**From:**  
**Sent:** 20 June 2024 12:58  
**To:** DCAdmin; Nick Hirst  
**Cc:**  
**Subject:** Planning Application number 2024/70/91236/W Lingards Road, Slaithwaite

Project :	Housing at Lingards Road, Slaithwaite.		
Client :	SB Homes.		
Drawing :	Plot 23 - Alternative layouts with garage.		
Scale :	1:100.	Date :	Nov 2023
Dwg No :	2019 572 Sk 13	Rev :	K

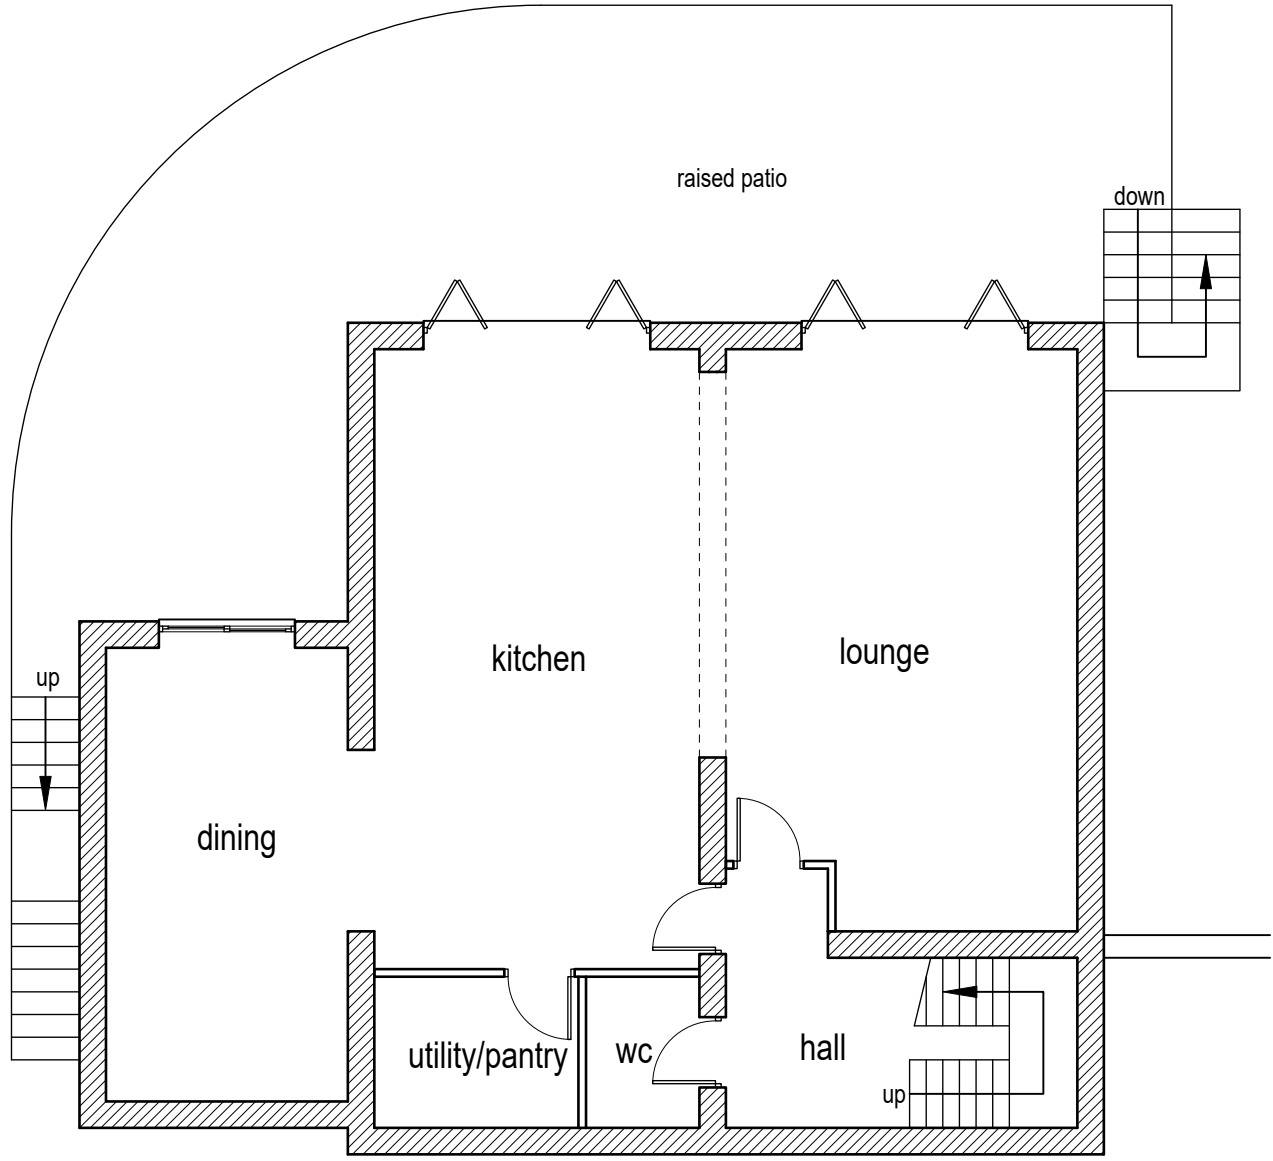
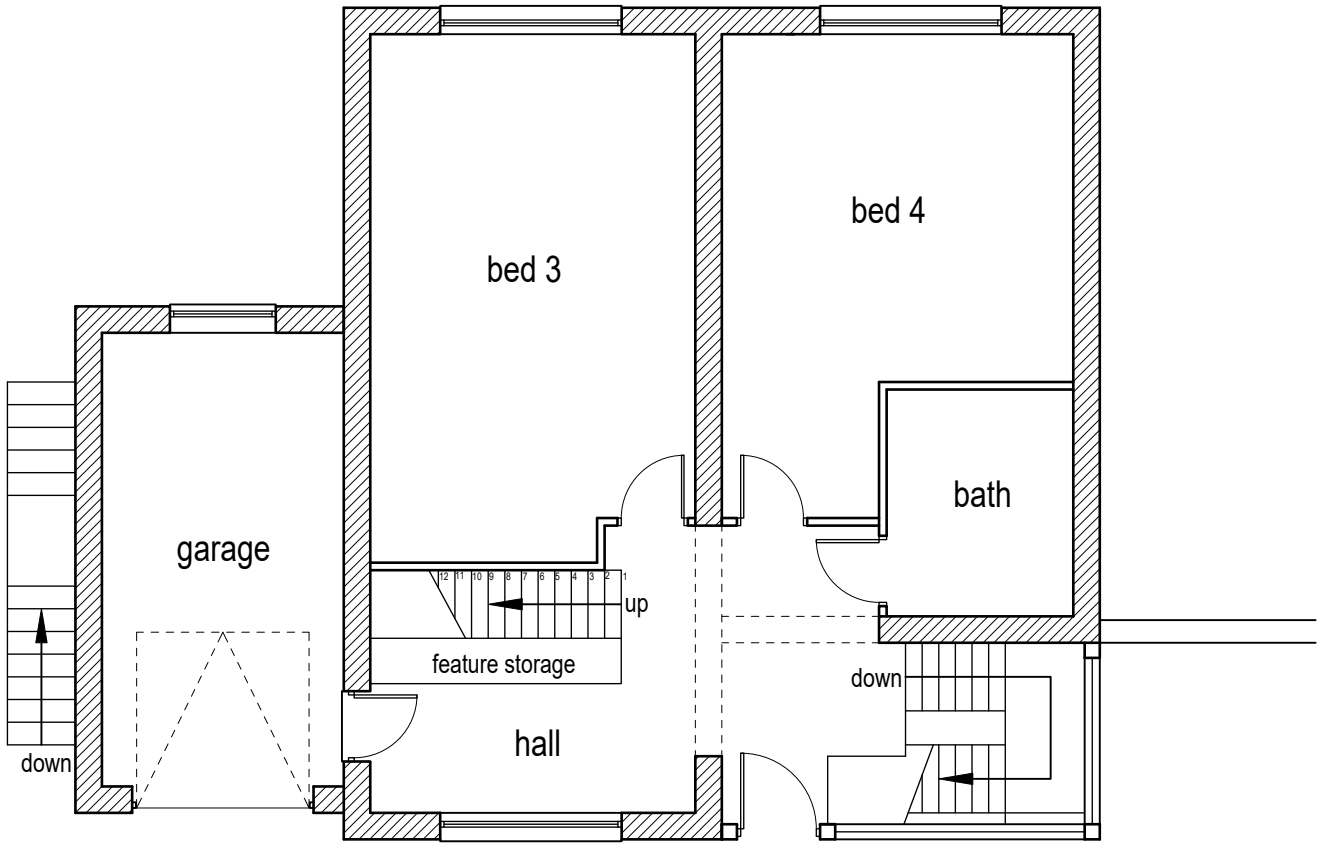
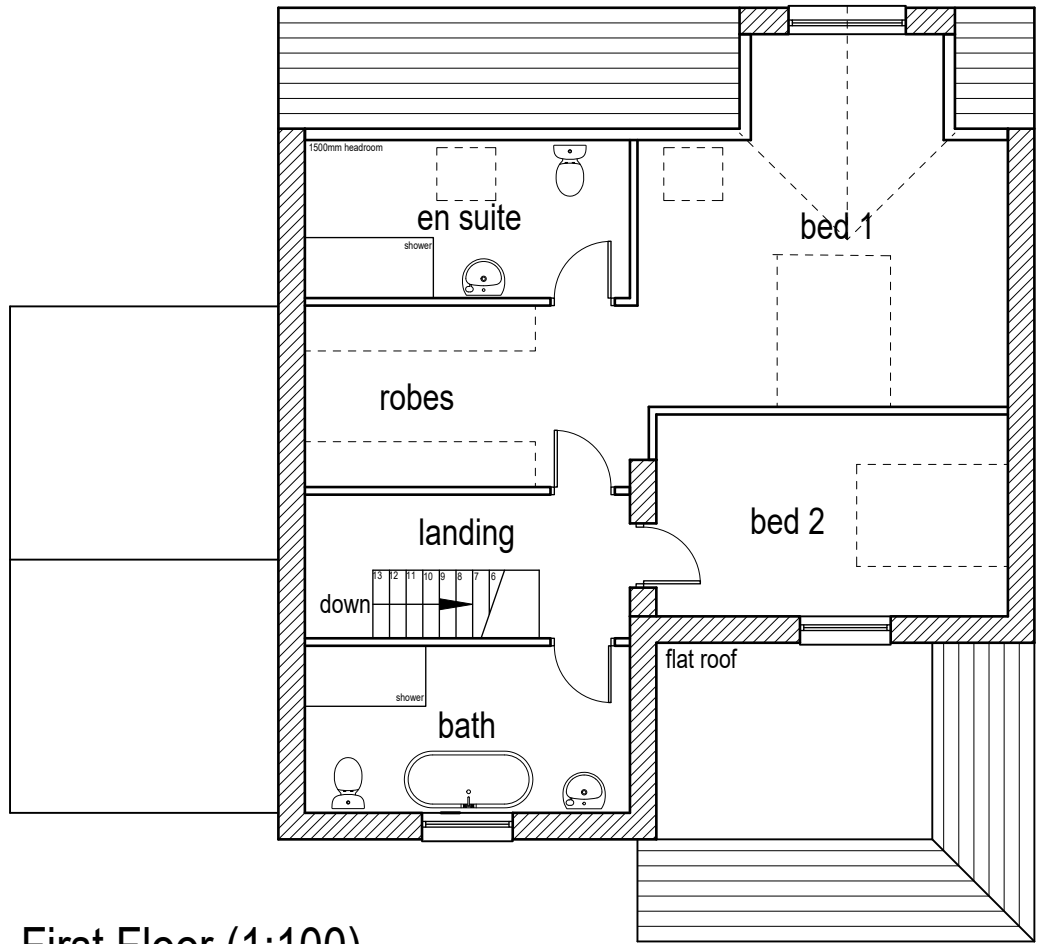
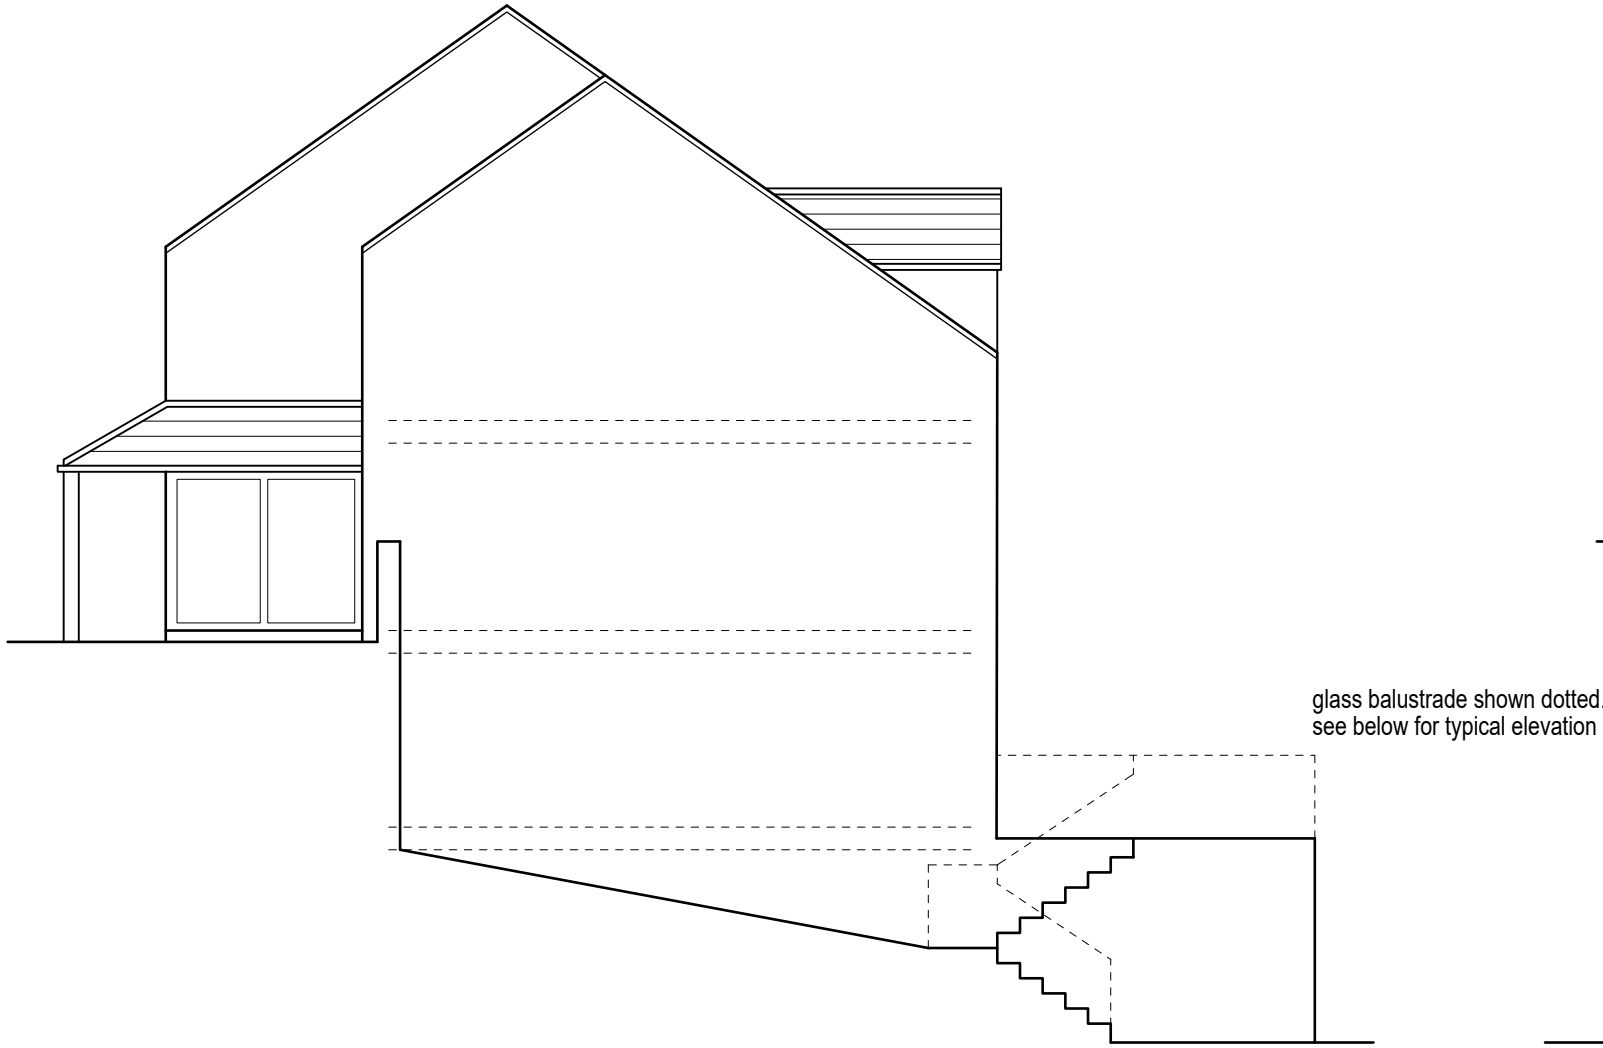
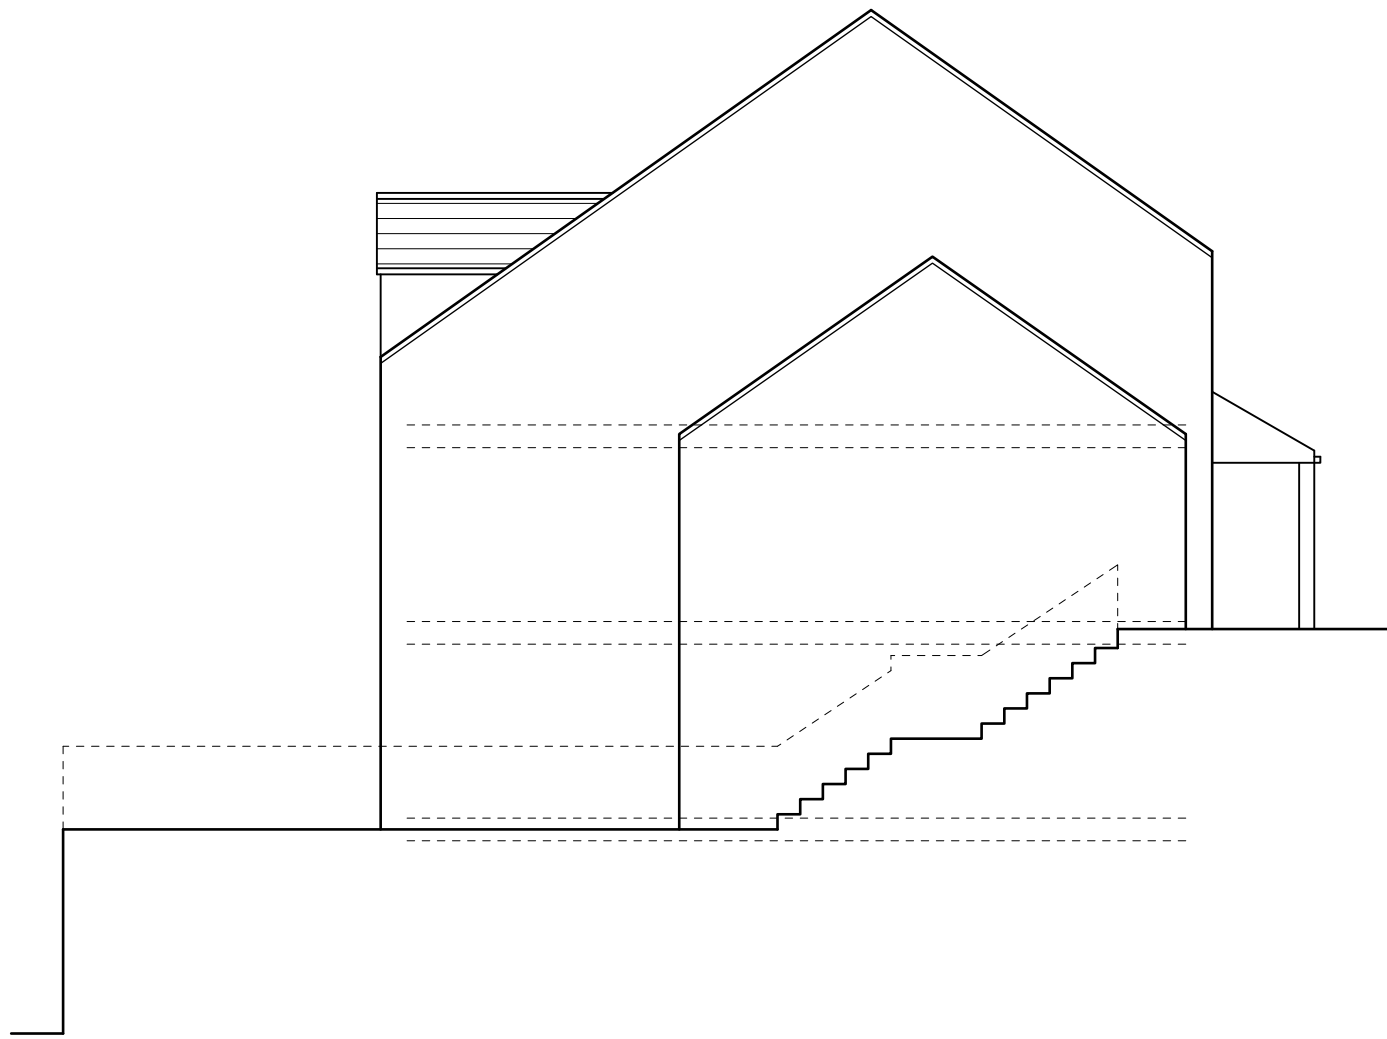
- The proposal to construct “basements” underneath the already high and top heavy dwellings is ridiculous and completely unacceptable. Throughout this planning process we objected to the three storey high facades on the Northern elevations, sat on top of raised platforms and retaining walls. This was because of the devastating impact they will have on the wider landscape viewed from Manchester Road or across the valley. It is staggering to now see proposals which effectively make the properties in to a usable FOUR STOREYS high. Although the “basement” proposal does not currently include windows and doors on the North Facing elevation it is easy to see that future residents will seek to use permitted development rights to “open up” the basement and remove the now “false” platform on the Northern side. In effect the new proposals are setting up a situation where the accommodation can be easily converted from three to four storey. In effect they set up a situation where utterly unacceptable proposals can be delivered “through the back door”.

Detail
PLANNING LAYOUT - PLOTS 23, 34/35

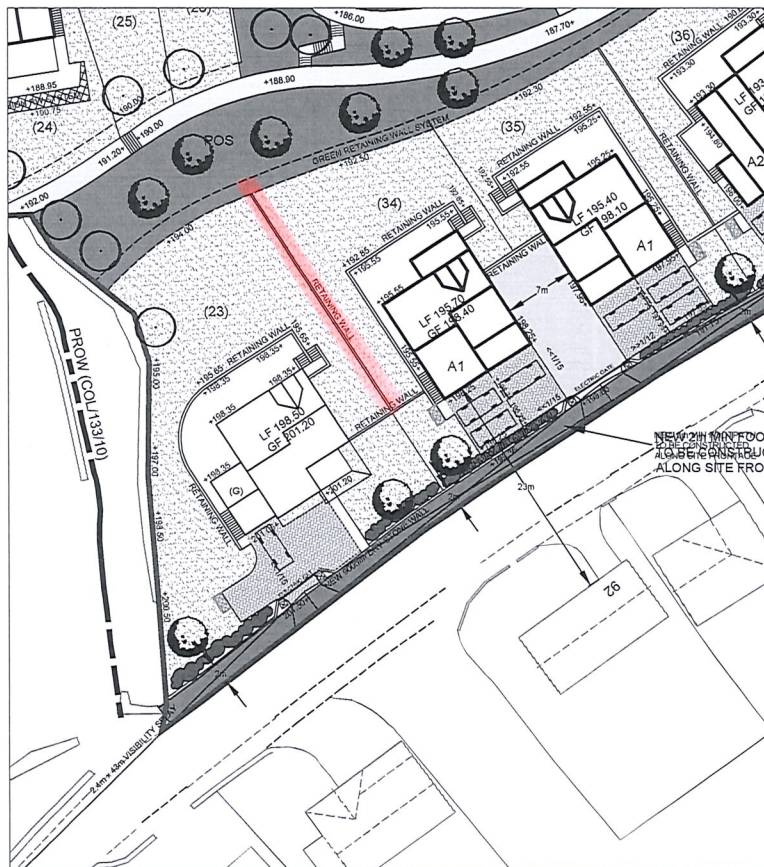
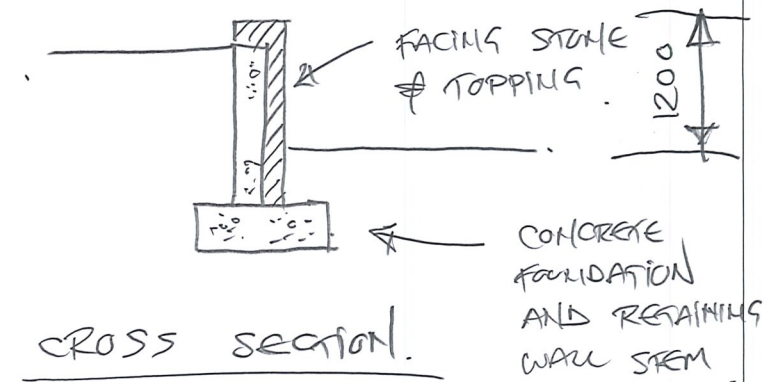
- The proposal to retain the original “building line” but now construct car ports in front of the approved “house building line” will have a devastatingly negative impact on the streetscape. It will effectively reduce the house separation distance shown on the approved plans down from 21 metres to an estimated 14 metres and drastically reduce the landscaping distance in the gardens of the new properties. Note that the developer does not put dimensions on his plans and one has to wonder why this is the case. Given that the views of existing residents have been ruthlessly swept aside during this entire planning process, this latest example of a brutal loss of amenity for existing residents is completely unacceptable. Were the developer to recognise the damage that his proposals would do to Lingards Road and move the entire house building line and car port positioning back some 7 metres into the field, this proposal for car ports instead of garages might be acceptable. As a final point relating to the car port positioning please remember that existing properties on the South side of Lingards Road would look down onto the car port roofs and any benefit that the original approved proposals gained from road side and garden landscaping would be completely lost. The new proposals may be OK for residents in the new properties but, as usual, the developer has not considered the impact on existing residents.
